Application for a non-material amendment following a grant of planning permission.

Number	41
Suffix	
Property name	Hillside
Address line 1	Station Road
Address line 2	Gedney Hill
Address line 3	
Town/city	Spalding
Postcode	PE12 0NP
Description of site location must be completed if postcode is not known:	
Easting (x)	533270
Northing (y)	309974
Description

Approved floor plans and elevations - 5856/02

Revised floor plans and elevations - 5856/02A

DATE: July 2018 SCALE: As Shown JOB No: 5856/02A

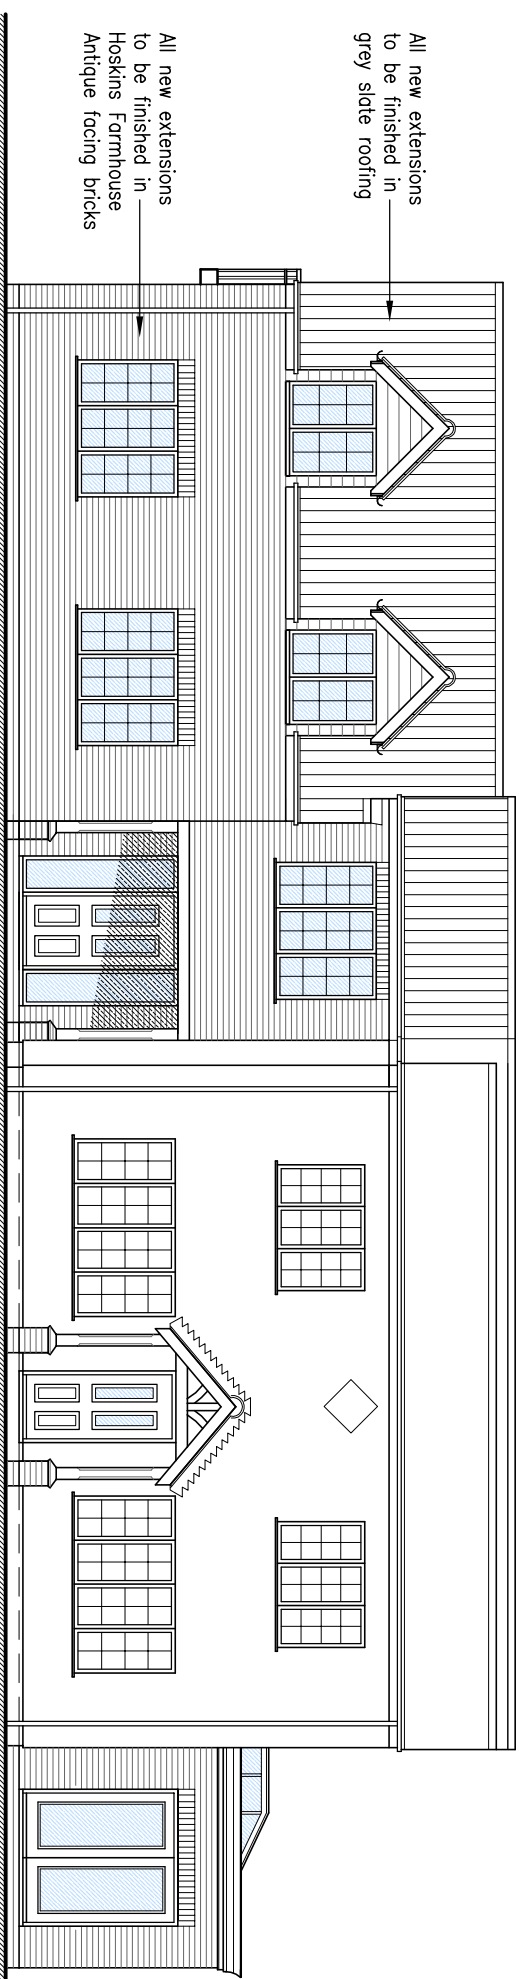
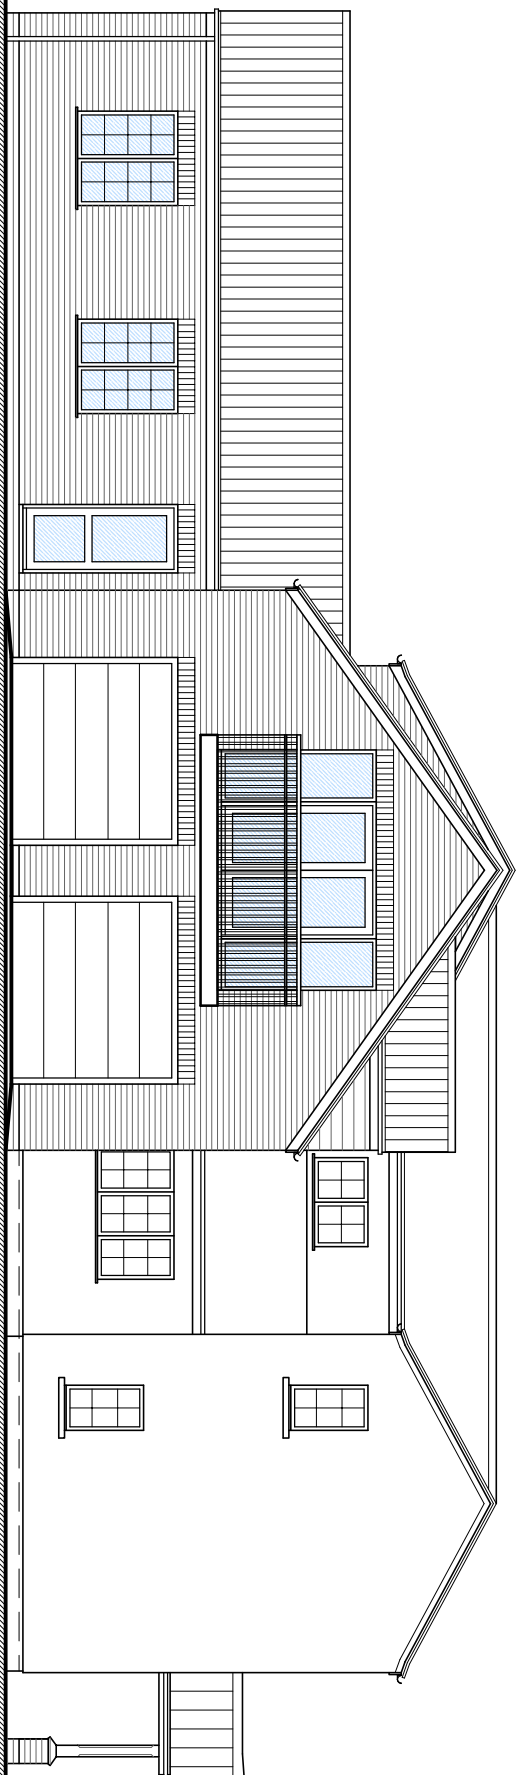
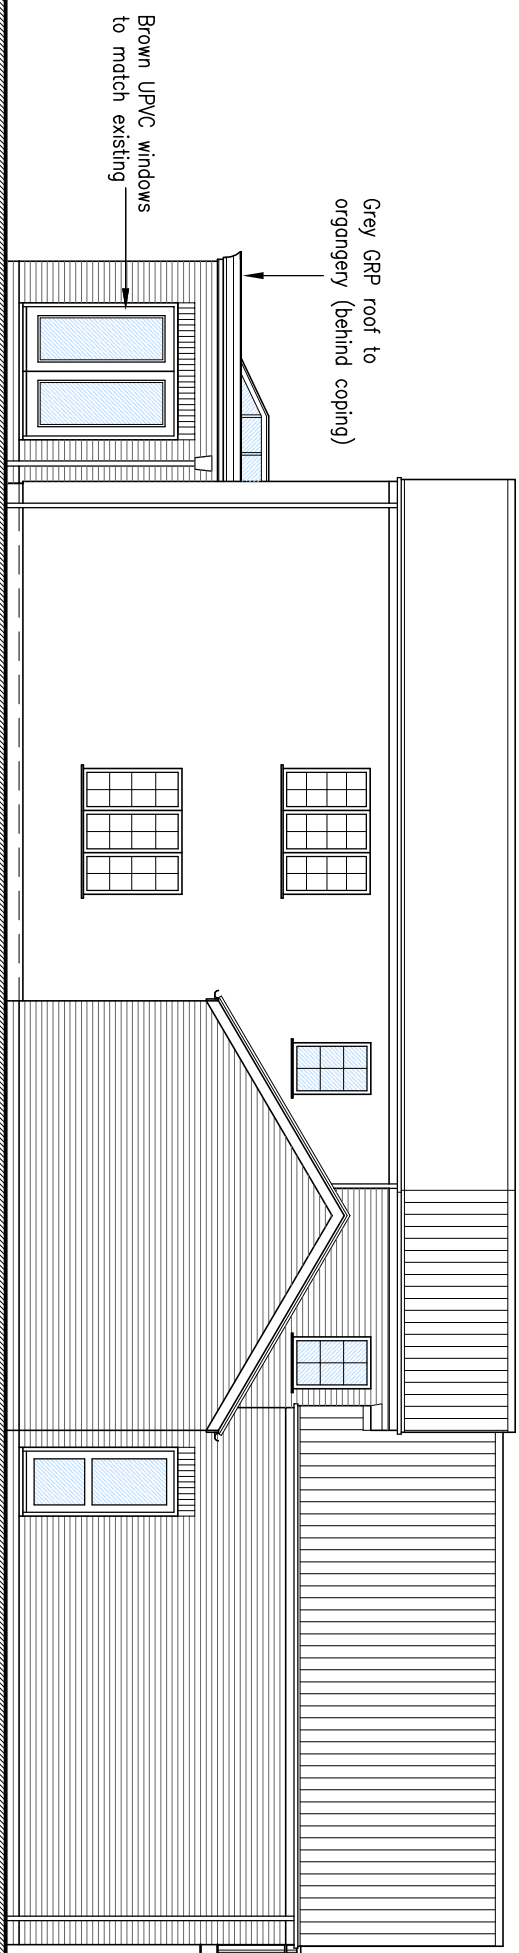
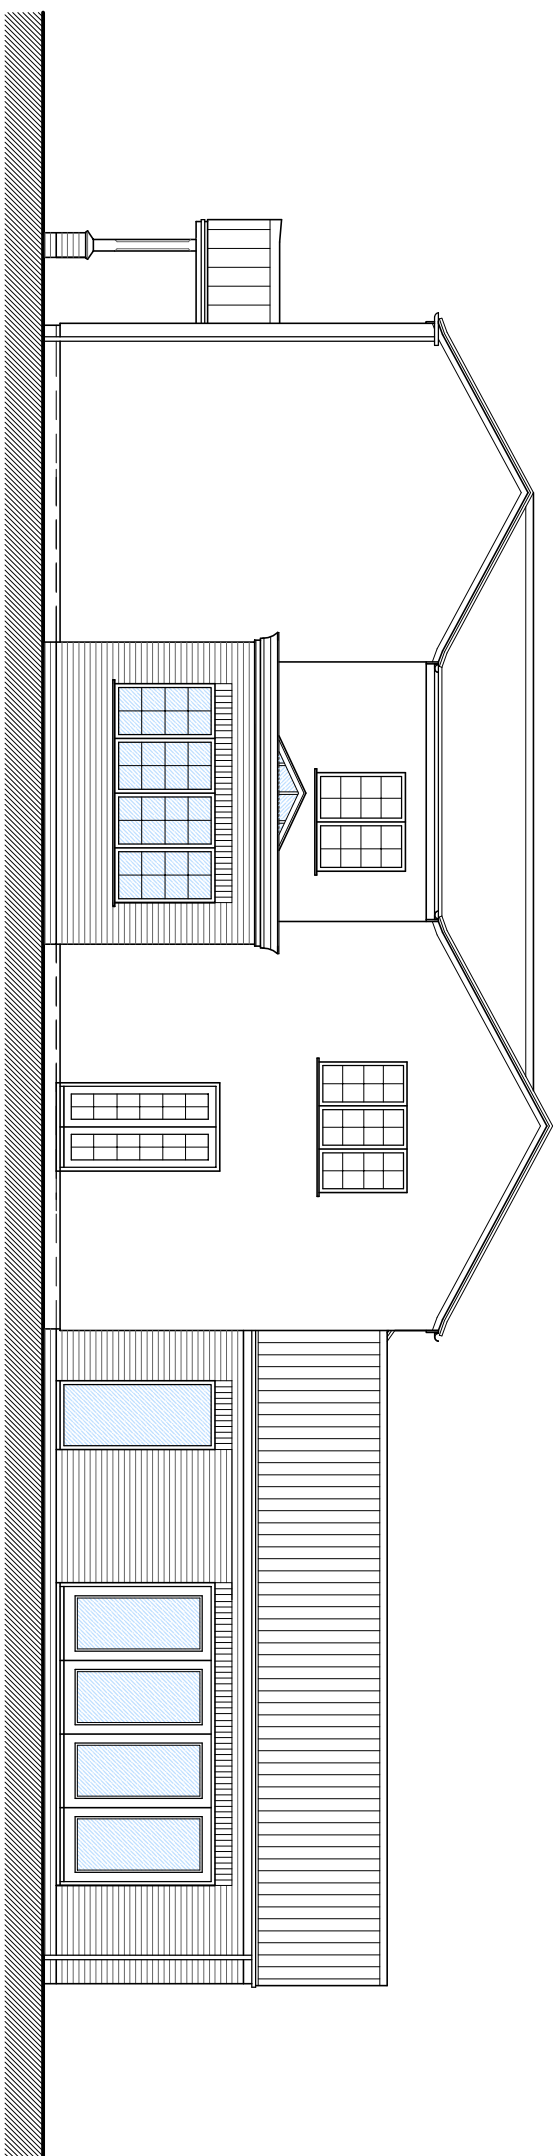
1. Change 3-leaf bi-fold doors on side elevation for window with dwarf wall below.
- 2 change windows on front and rear elevation for 2-leaf bi-fold doors.
